**DELEGATED DECISION FOR APPLICATION FOR CERTIFICATE OF  
LAWFUL DEVELOPMENT**

Reference no.: 2024/CL/90095/E

Site: 2, Heron Close, Ravensthorpe, Dewsbury, WF13  
3TH

Description: Certificate of lawfulness for proposed rear dormer

PROPOSED ROOF PLAN

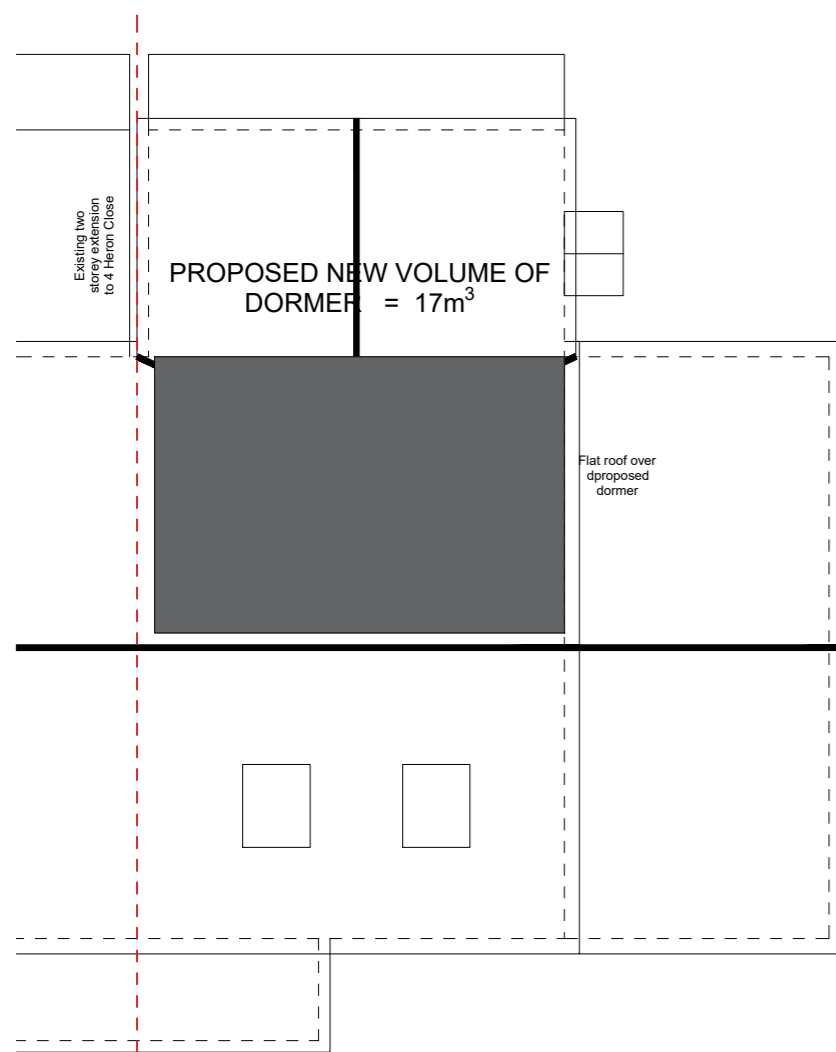
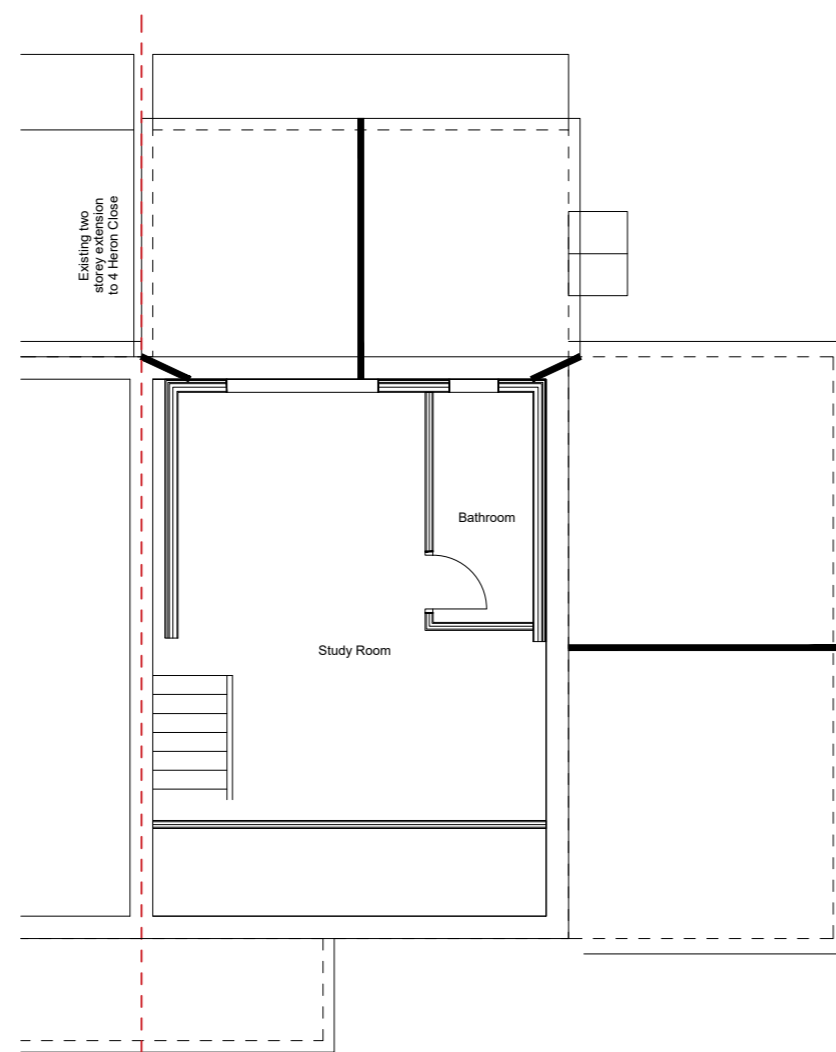
The dormer would adjoin the roof over the rear extension and would have a width of 5.4m, a height of 1.9m and a depth of 3.6m.

Total proposed roof enlargement – 18.5 cubic metres

It is noted that the previous two storey enlargement has been erected and the roof space will be adjoined to the proposed roof enlargement. The roof space of the two storey enlargement is 7.9 cubic metres

Total roof enlargement = 26.4 cubic metres.

Article 3(5) of the GPDO sets out that schedule 2 of the Order does not apply where permission in connection with an existing building, the building operations involved in the construction of that building are unlawful. In this instance the permission for the two storey extension and the building works carried out differ significantly with the lowering of the dual pitched roof of the extension to accommodate the proposed roof enlargement. This has the effect of rendering the building works carried out as deviating from the approved plans and therefore unlawful as no other planning permission exists. Article 3(5) applies, therefore as the construction of that building and any part of that building when applying the statutory definition of “building”, is unlawful and as the proposed roof enlargement adjoins the unauthorised works, schedule 2 cannot apply.

The proposed rear dormer at 2 Heron Close would not constitute permitted development as set out in Article 3(5) and Schedule 2, Part 1, Class B of the Town and Country Planning (General Permitted Development)(England) Order 2015 as the proposed roof enlargement adjoins part of an existing two storey extension to the dwellinghouse that does not benefit from planning permission by virtue of deviation from the approved plans.

PROPOSED SIDE ELEVATION
(north west)

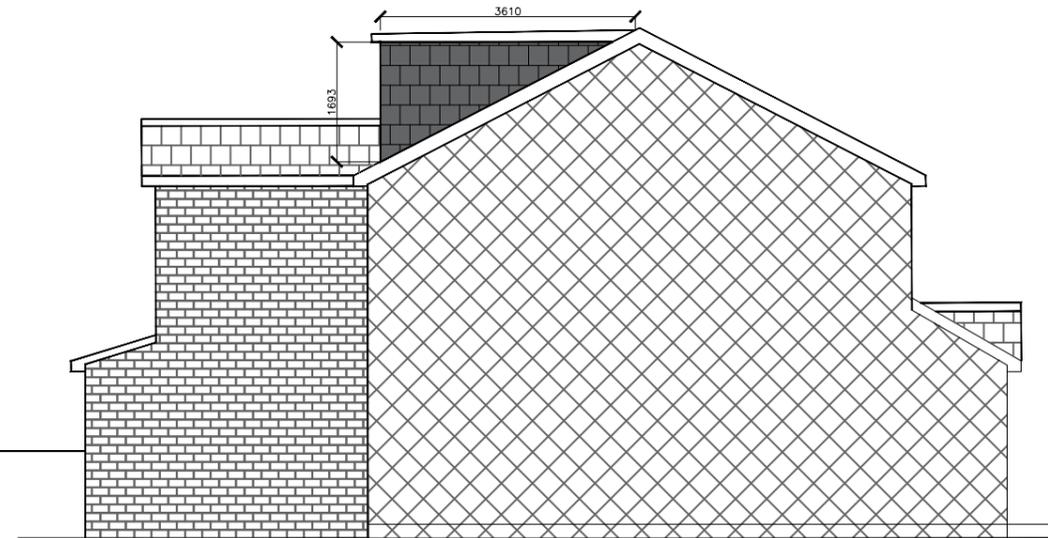
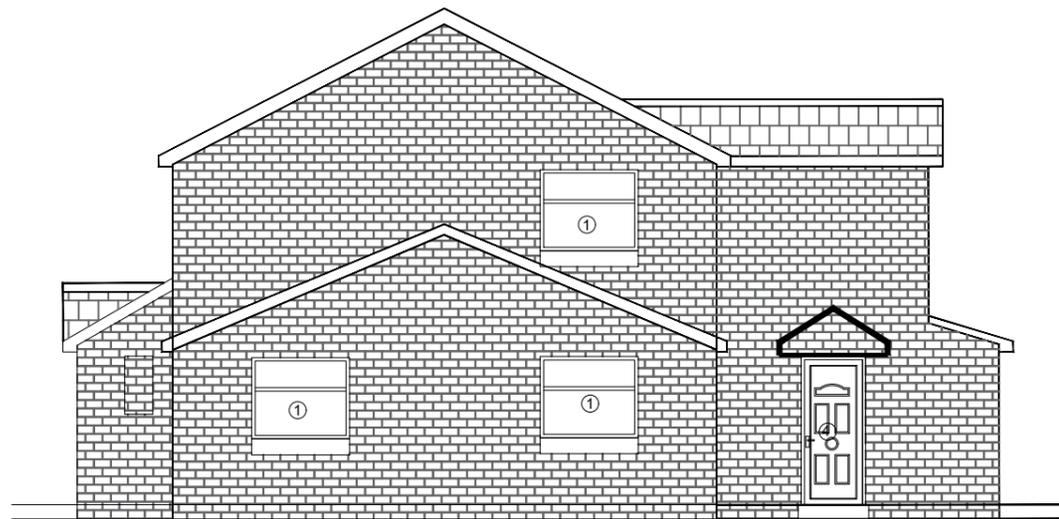
(b) any part of the dwellinghouse would, as a result of the works, exceed the height of the highest part of the existing roof; *The proposal does not exceed the existing height of the dwelling.*

(c) any part of the dwellinghouse would, as a result of the works, extend beyond the plane of any existing roof slope which forms the principal elevation of the dwellinghouse and fronts a highway; *The proposals would not extend beyond the existing roof slope on the principal elevation.*
